Submission to Oral Hearing

NA04.310286

XC212 (Ballycoskery Level Crossing)

Figure 4-9 XC212 Alternative options

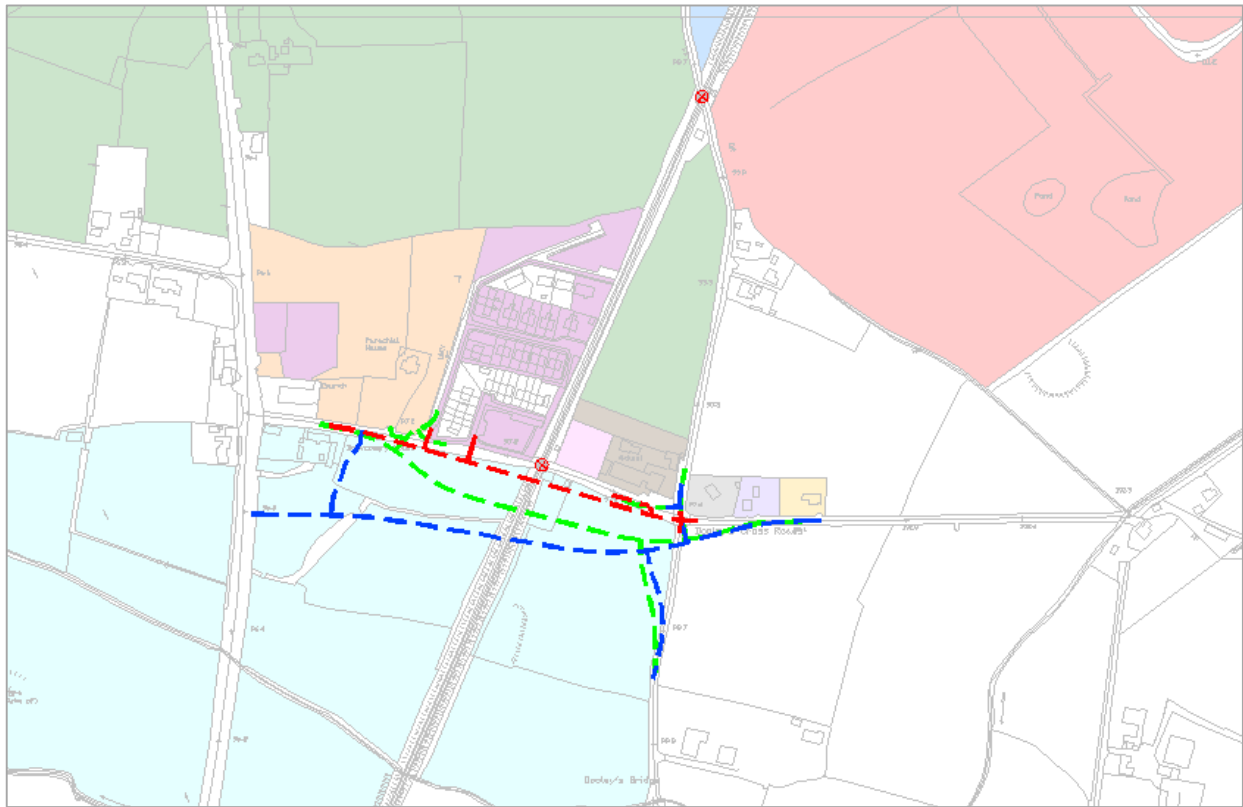
In the report a number of Alternative solutions have been proposed and should be given due consideration and evaluated fully. Perhaps somewhat more than was the case in yesterday's submissions by the Applicant.

1. Existing solution – Why has it been determined that a change is needed, other than the efficiency of the line for high speed trains and some references to safety concerns.
2. Automate the existing solution. We can't say that it is not viable as it is the proposed solution for XC 209 approx 2km north of XC212 and for several other crossings both on the Cork/Dublin line and on other lines.
3. Segregated single lane underpass controlled by traffic lights.
4. Segregated Dual Lane underpass or combined underpass.
5. Redesign the current proposal. Move location of bridge, Separate underpass for pedestrians.

The obligation to outline, consider and explain the ruling in or out of alternatives has been hopelessly inadequate in respect to this section of the route.
